CITY OF ALBUQUERQUE

January 29, 2019

Re: Soo BACK RESTAURANT & TAKEOUT
111 Hermosa Dr. SE 87108
Traffic Circulation Layout
Engineer's/Architect's Stamp **01-25-19 (K17D117)**

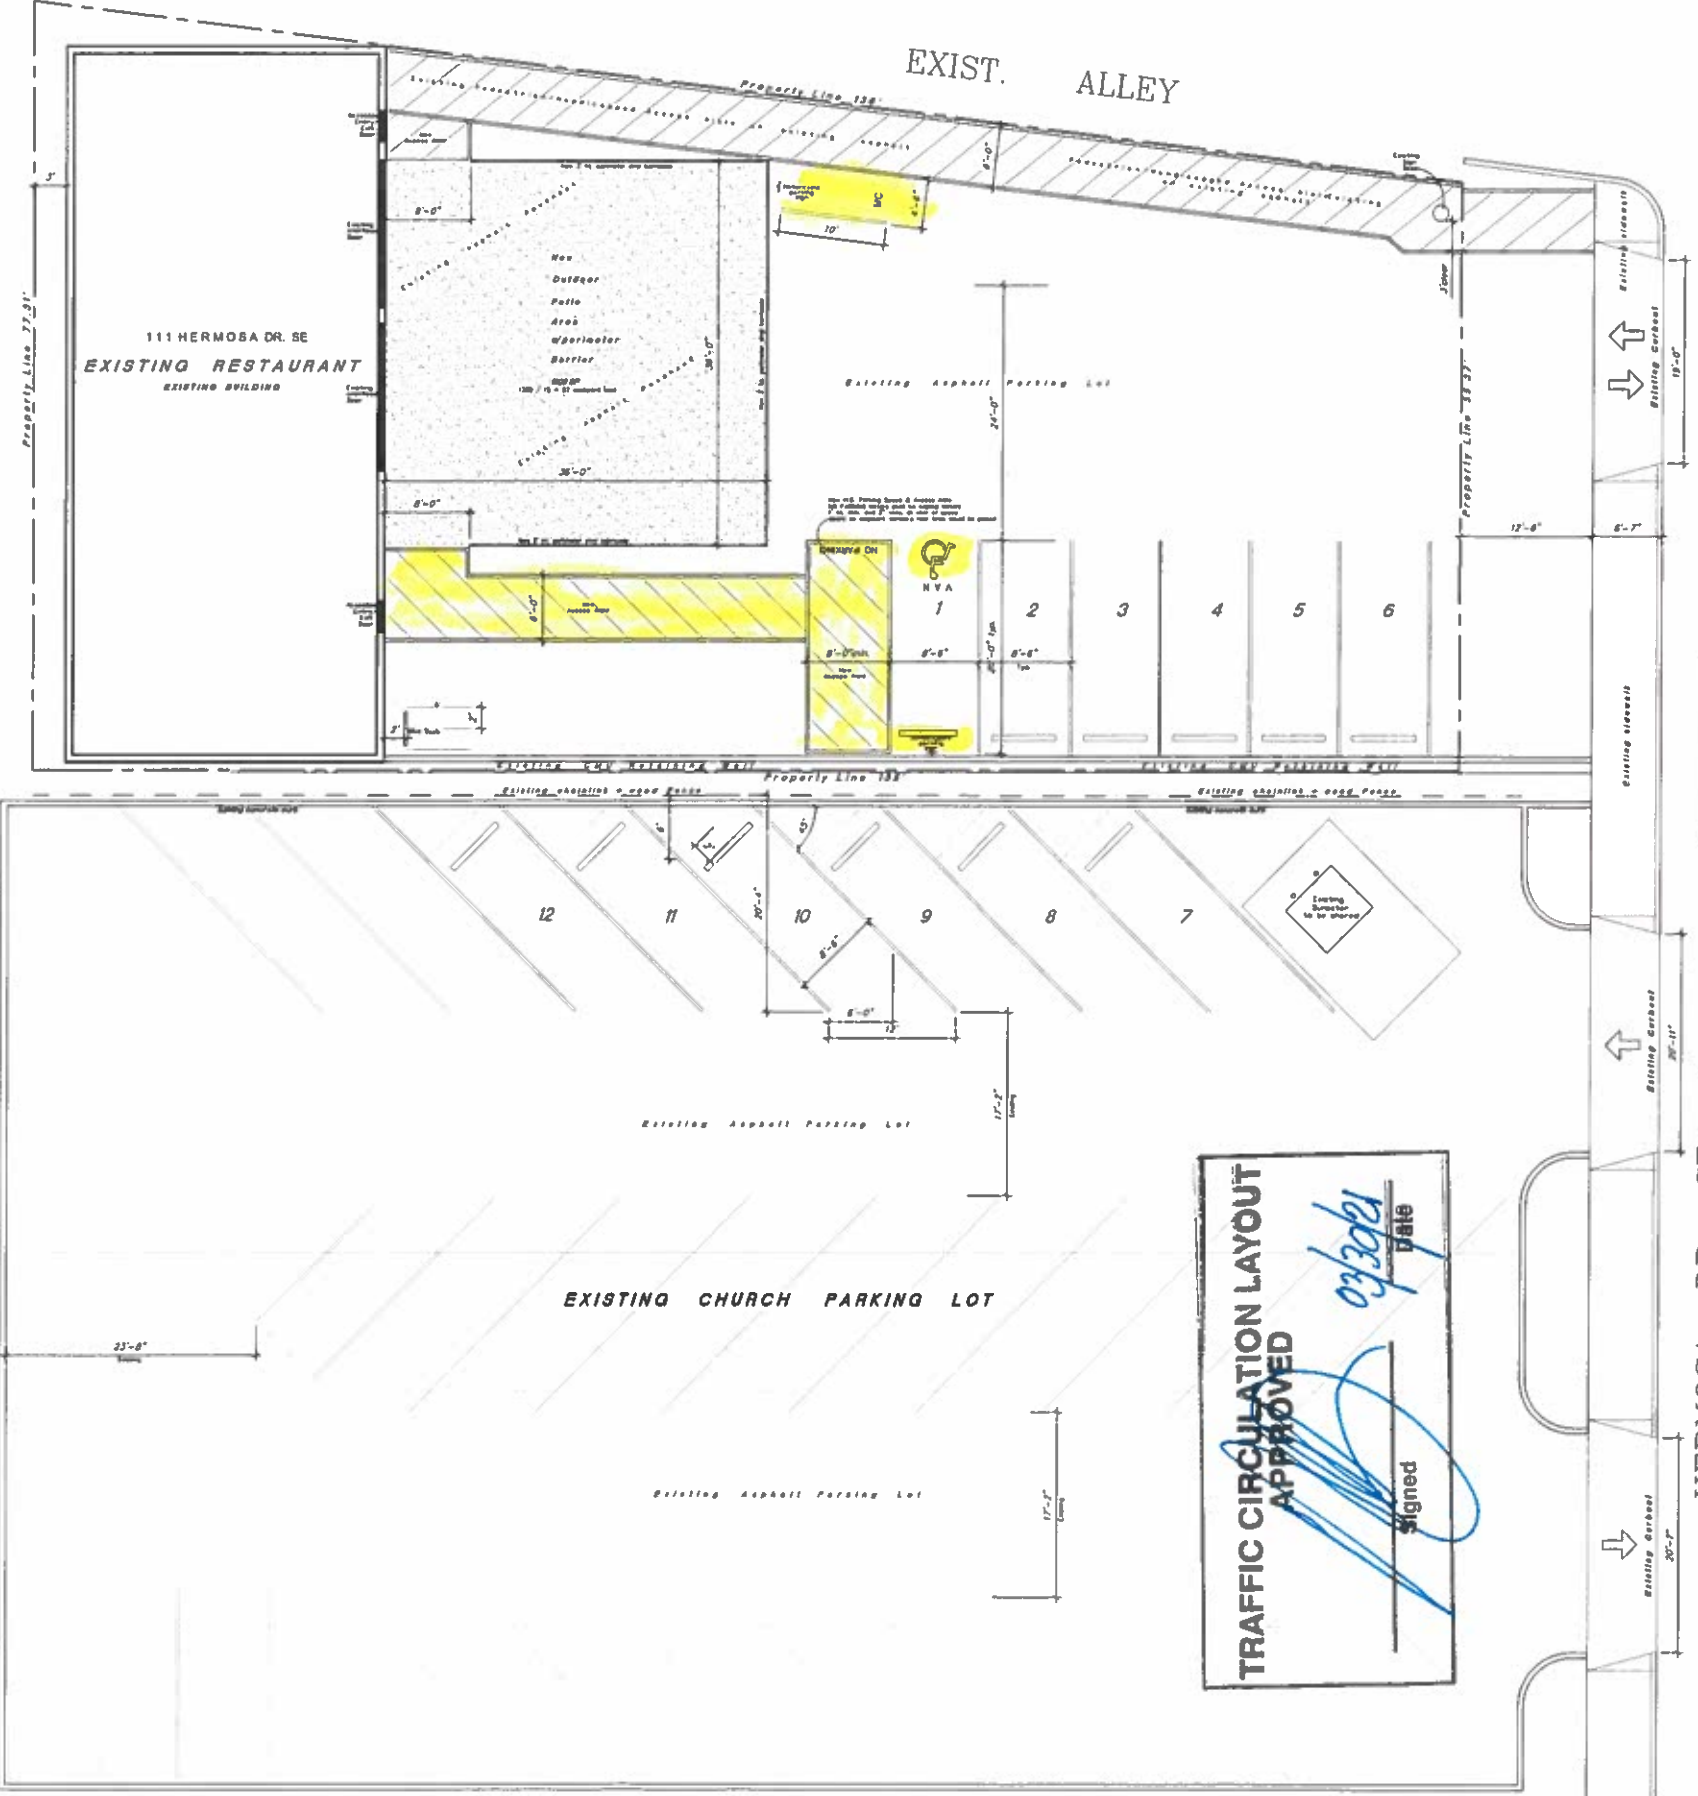
The TCL submittal received 01-25-19 is approved for Building Permit with the **condition of removing the parking space #10 which lies outside the property line**. A copy of the stamped and signed plan will be needed for each of the building permit plans. Please keep the original to be used for certification of the site for final C.O. for Transportation.
